TABLE 1
SOPA Comments in Response to
SDD-35283699_ SOPA Metro Station – Over and Adjacent Station Development

TABLE 1
SOPA Comments in Response to
SDD-35283699_ SOPA Metro Station – Over and Adjacent Station Development

Figure 5-3 Access and egress routes for cyclists

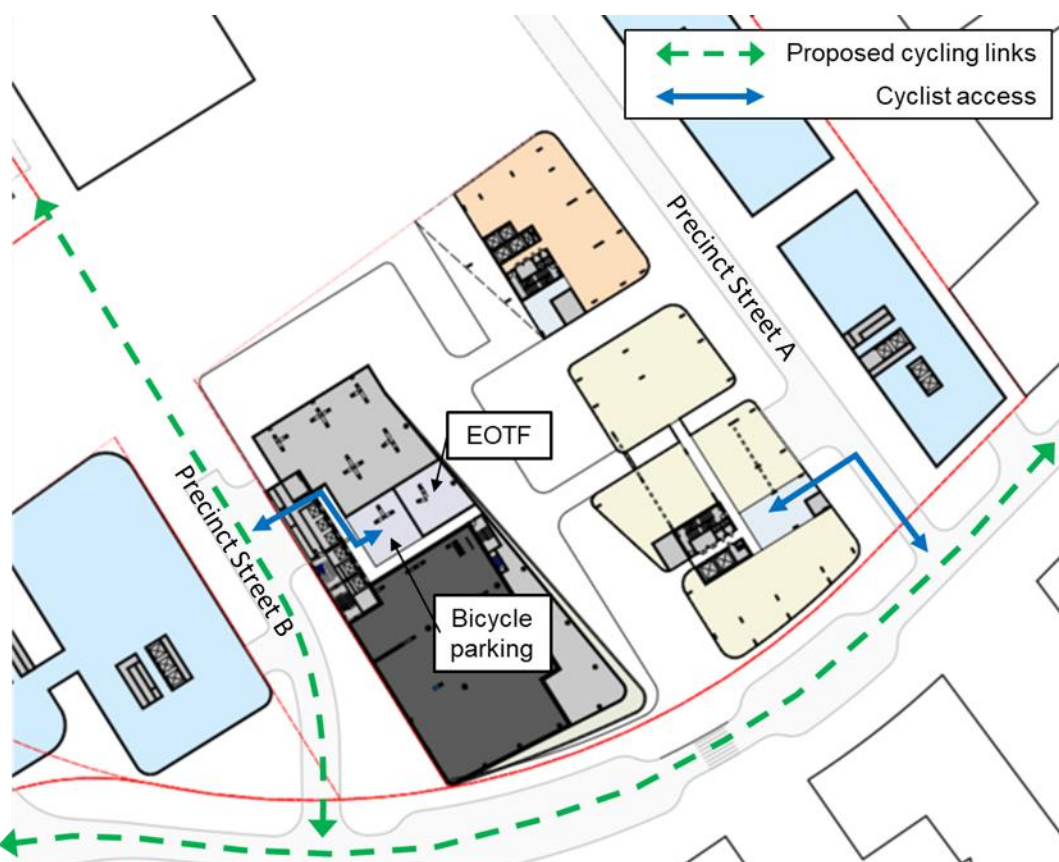
5	EIS (SDD-35283699)	33	3.6 Vehicular access and parking	Bicycle Parking: There may be safety concerns regarding the bicycle parking and end-of-trip facilities located on Level 3 being accessed via the loading dock of Building 1 as indicated. (Ref. Scheme Sheet 13). Where will Metro bicycle parking be located? Buildings 2 & 3 residential bicycle parking is undersized, and access appears to be problematic - via Building 3 apartment lift lobbies? (Ref. Scheme Sheet 17). No. Please outline further how this will all work safely and be sized and accessed appropriately.
6	EIS (SDD-35283699)	37	3.9 Interface levels	The staging of the SSD Public Domain Scope area in relation to the other areas of public domain is unclear, particularly around the station entrances (Figure 3-8). Please clarify further.
8	EIS (SDD-35283699)	57	6.2 Built form and urban design	6.2.2 Tower Elements - "The Building 1 tower setbacks vary and include a 2.5m primary setback and nil secondary setback to Precinct Street B (due to structural requirements)". The extent of tower within this 2.5m setback has previously been questioned, specifically the areas of amenities and corridor located within the setback. Note that the SOP Master Plan (2.4.5 Setbacks) states that "a 2.5m protrusion into secondary setback is permissible only for tower core, bracing and structural requirements." Also, it is stated that "Building 3 will have a maximum height of 45 storeys (RL 171.00)...". Building height and final ground RLs require clarification.

27	Appendix H: Indicative Reference Scheme	13	Level 03 Floor Plan	Bicycle Parking and EOT - Is access to Level 3 via a lift requiring travel thru the ground floor Loading Area acceptable. (Where will Metro bicycle parking be located?).
28	Appendix H: Indicative Reference Scheme	14	Typical Tower Level	How much of the tower "core" protrusion to the boundary on the south-west façade is "tower core, bracing and structural requirements"? (SOP MP 2.4.5 Setbacks). Please clarify if the desire for a 1500 sq metre commercial floor plate has determined the envelope of the building on this site.
29	Appendix H: Indicative Reference Scheme	17	Basement 01 (Bldg 2 & 3)	Bicycle Parking requires clarification - Is the area for cycle parking and EOT adequate? Is this for Commercial only or for residential as well? Is the access for commercial parking via lobby lifts appropriate?
